**Re: Circle K
9800 De Vargas
Traffic Impact Study (M09D012A) TRANS-2026-00009**
Submittal dated January 13, 2026
Via email asutiono@jmcivileng.com and ABQ-PLAN

The Traffic Impact Study received on January 13, 2026, has been reviewed by the City of Albuquerque Planning Development Transportation Section and has the following comments.

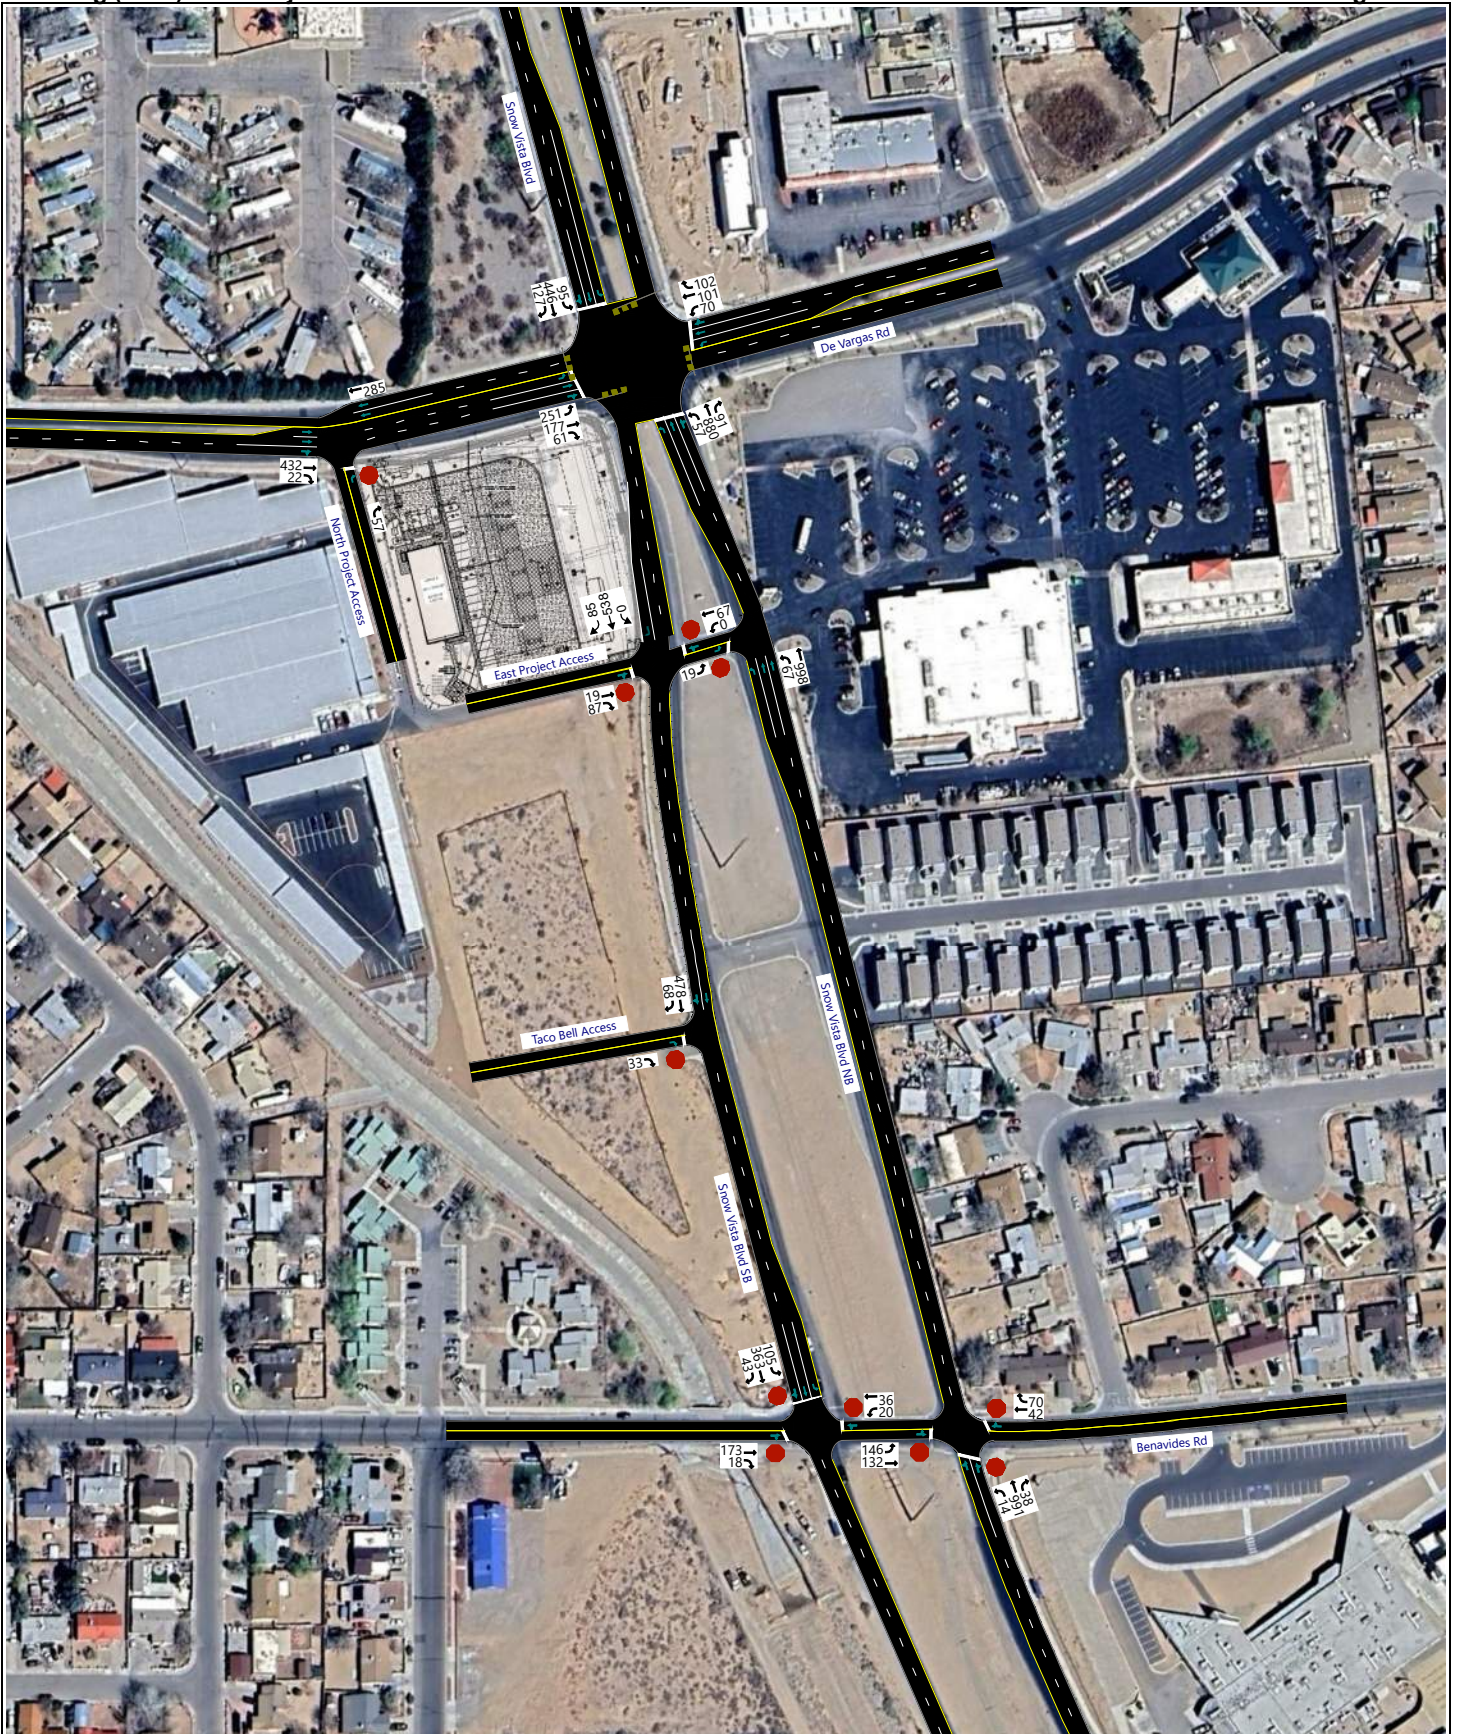
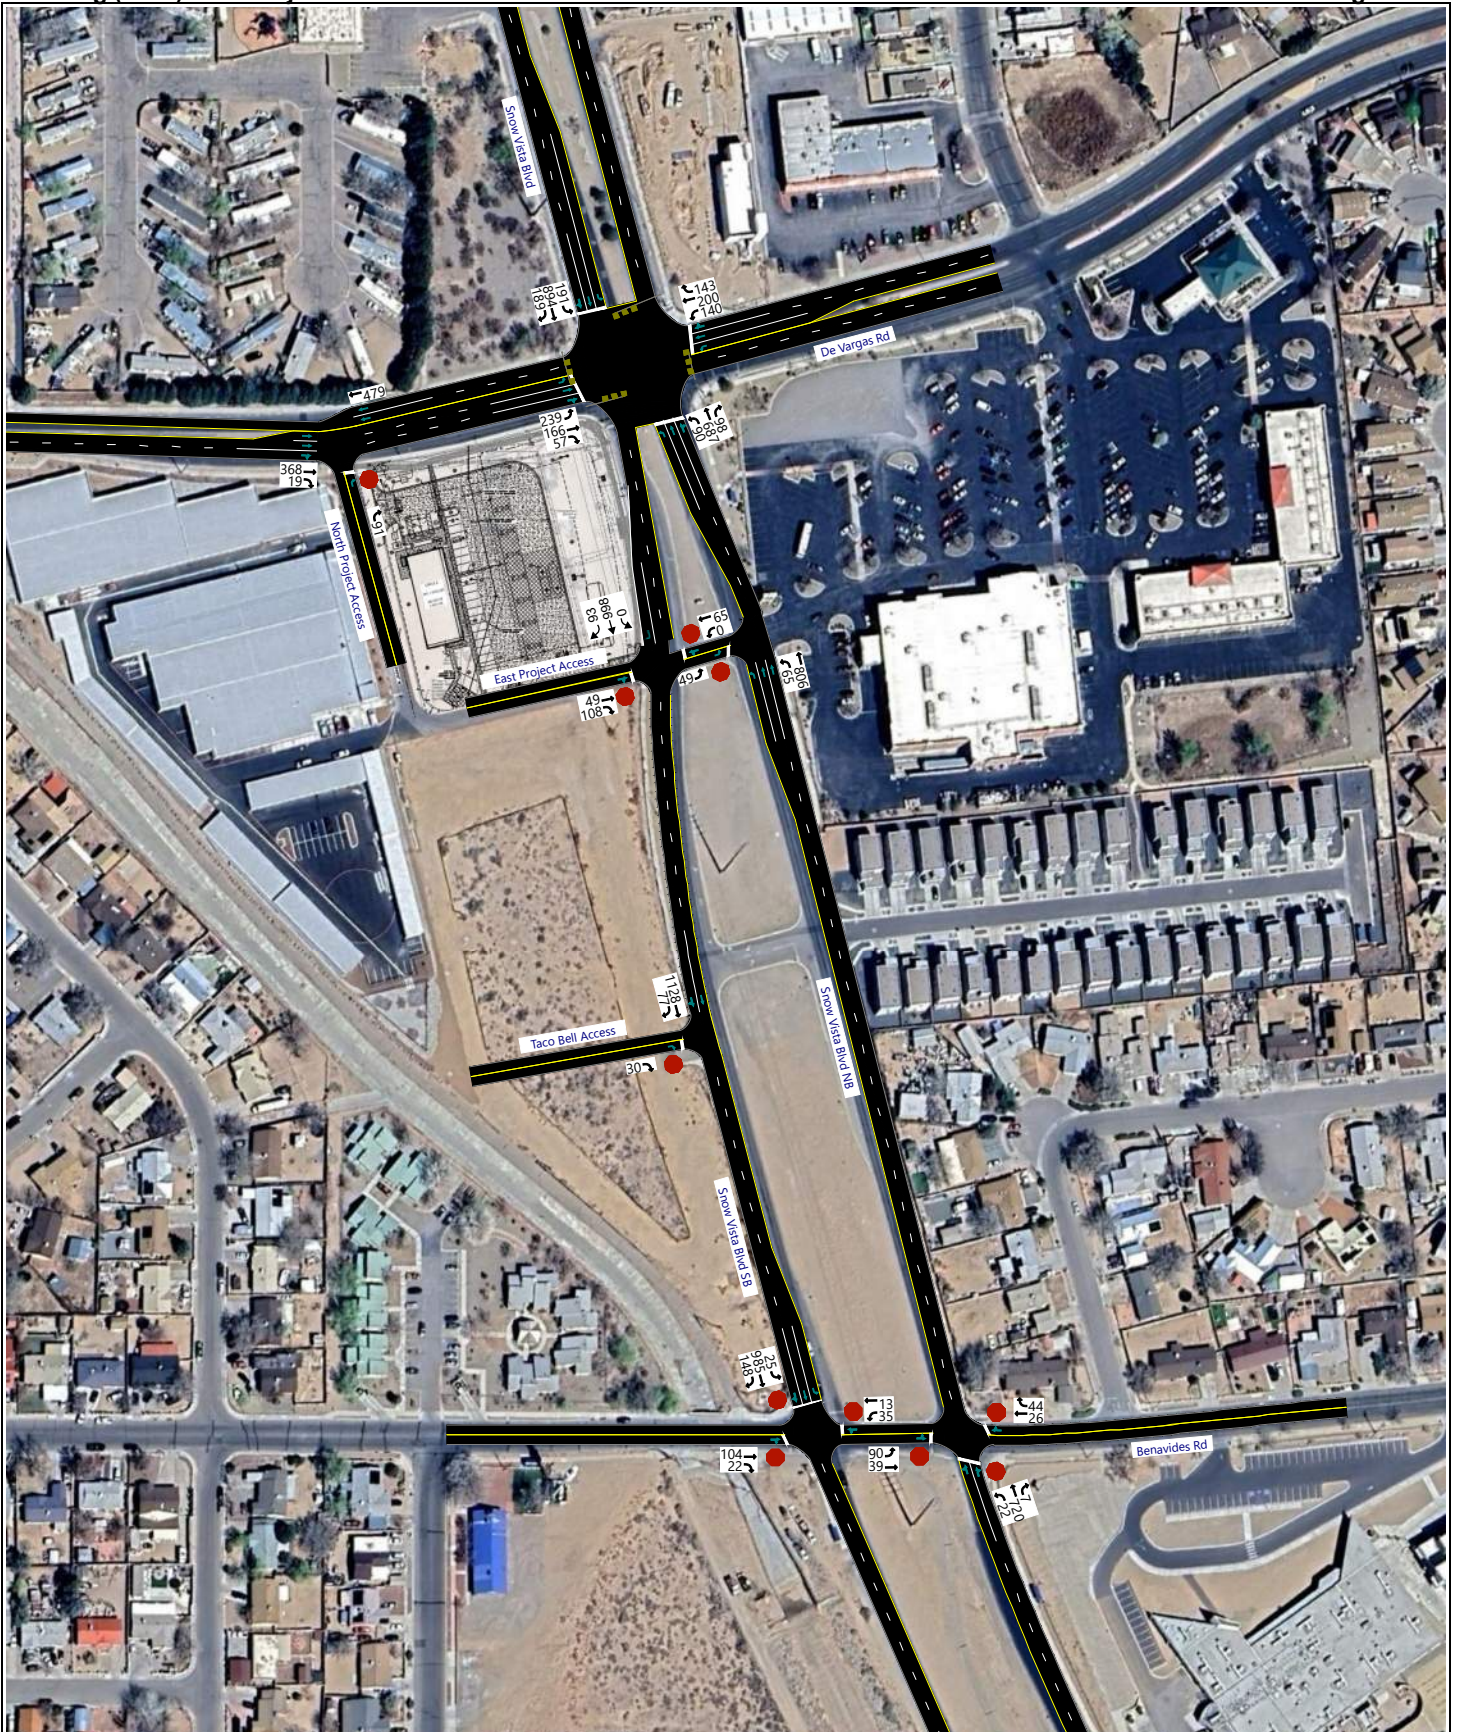
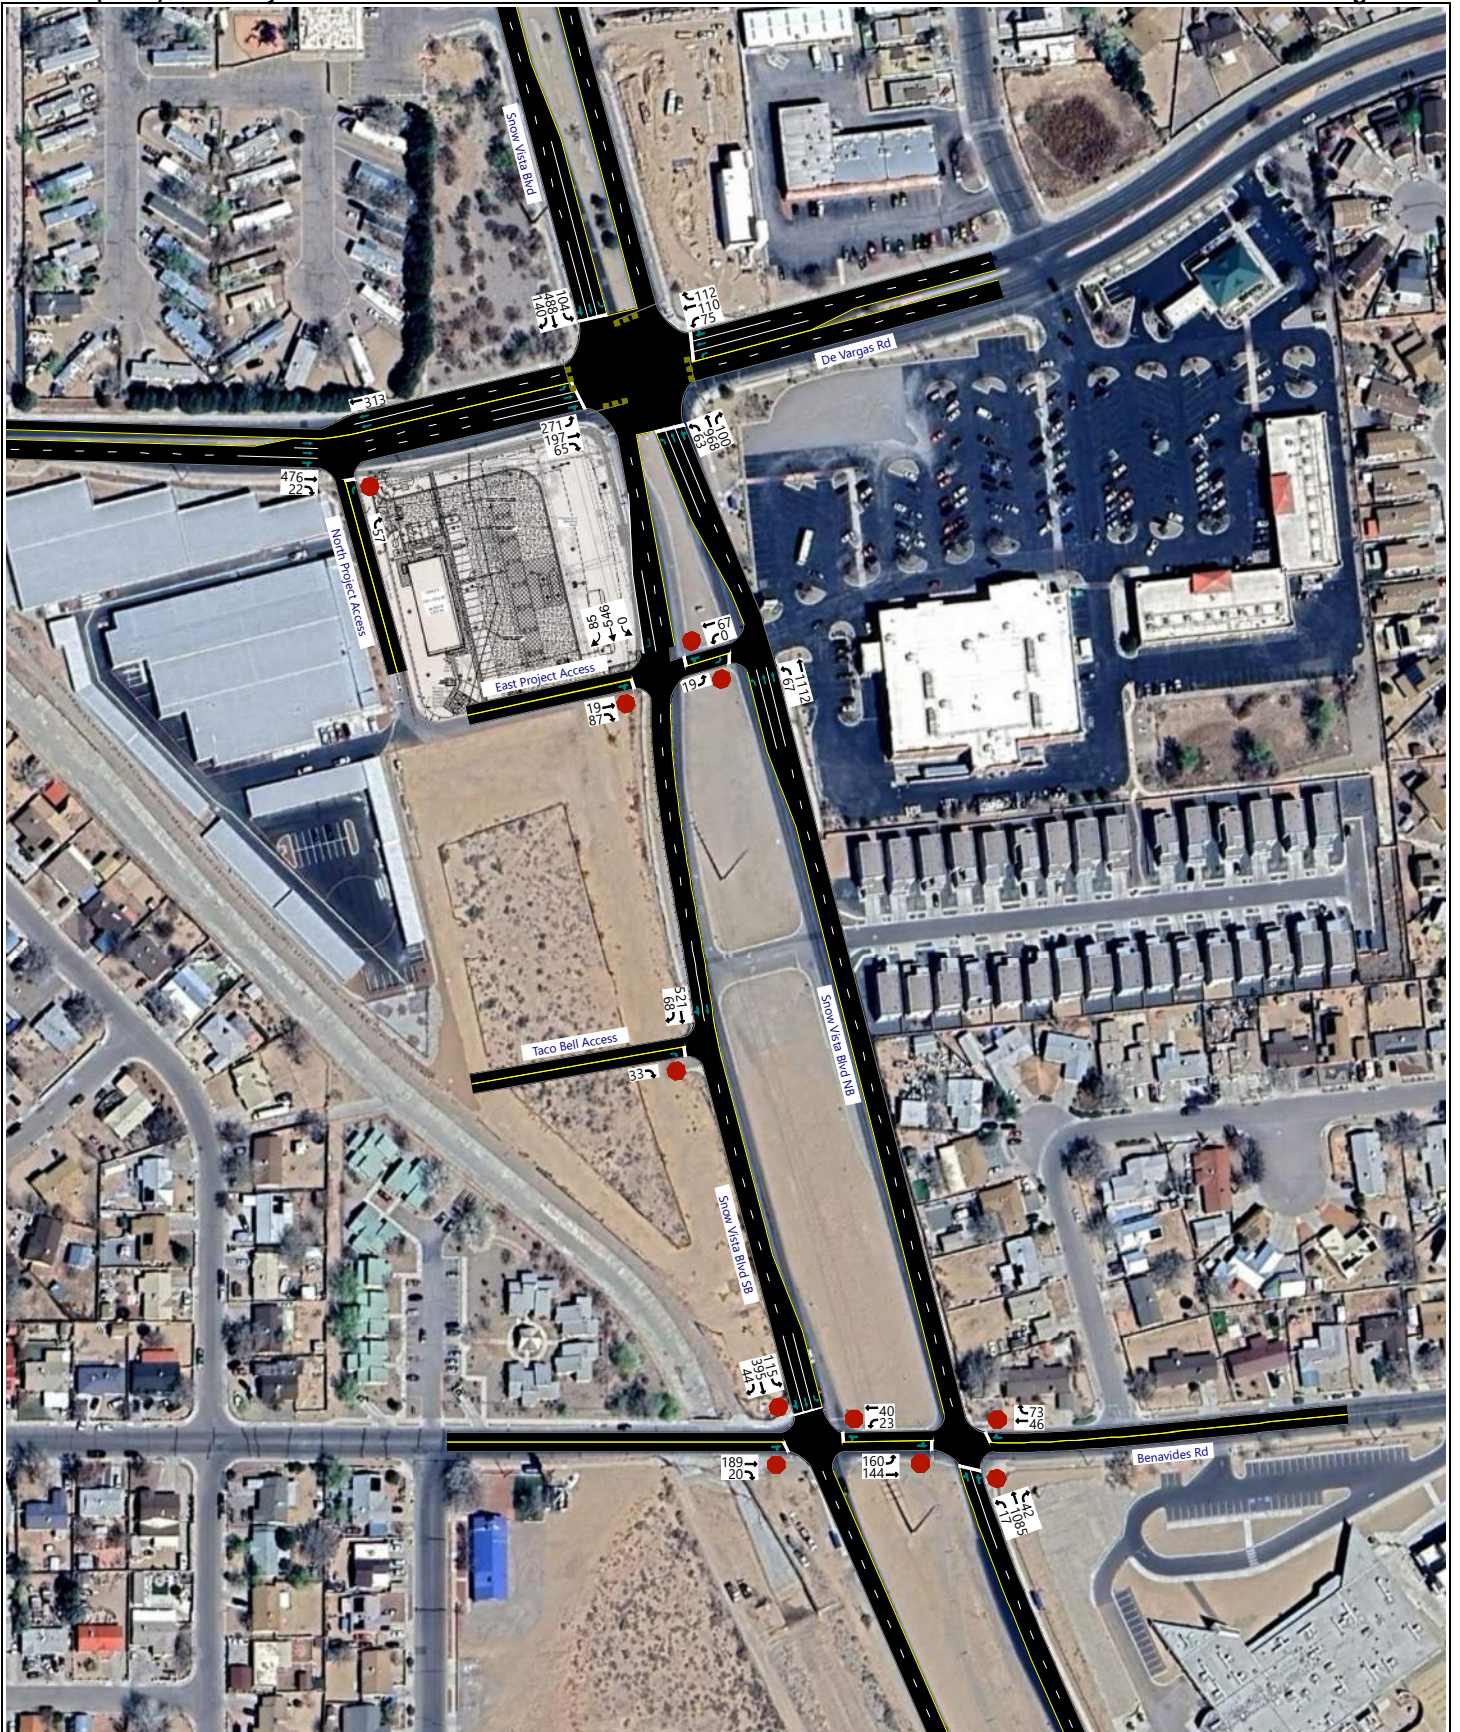
1. Please create tables out of the data shown on the Trip assignment figures. The site plans have the information but they are a bit hard to read due to the size you were forced to use. Adding tables as a summary of this data would help.
2. Table 4 and Table 5 show the LOS B for the intersections in the study. If you can please make sure that you are consistent with the LOS designations. You have used a combination of upper and lower case letters for LOS designation where they should all be upper case.
3. Page 13 for your Mitigation Measures you recommend a traffic signal be placed at Benavides and Snow Vista. In order to consider this, you need to perform a signal warrant analysis based on the MUTCD signal warrants.
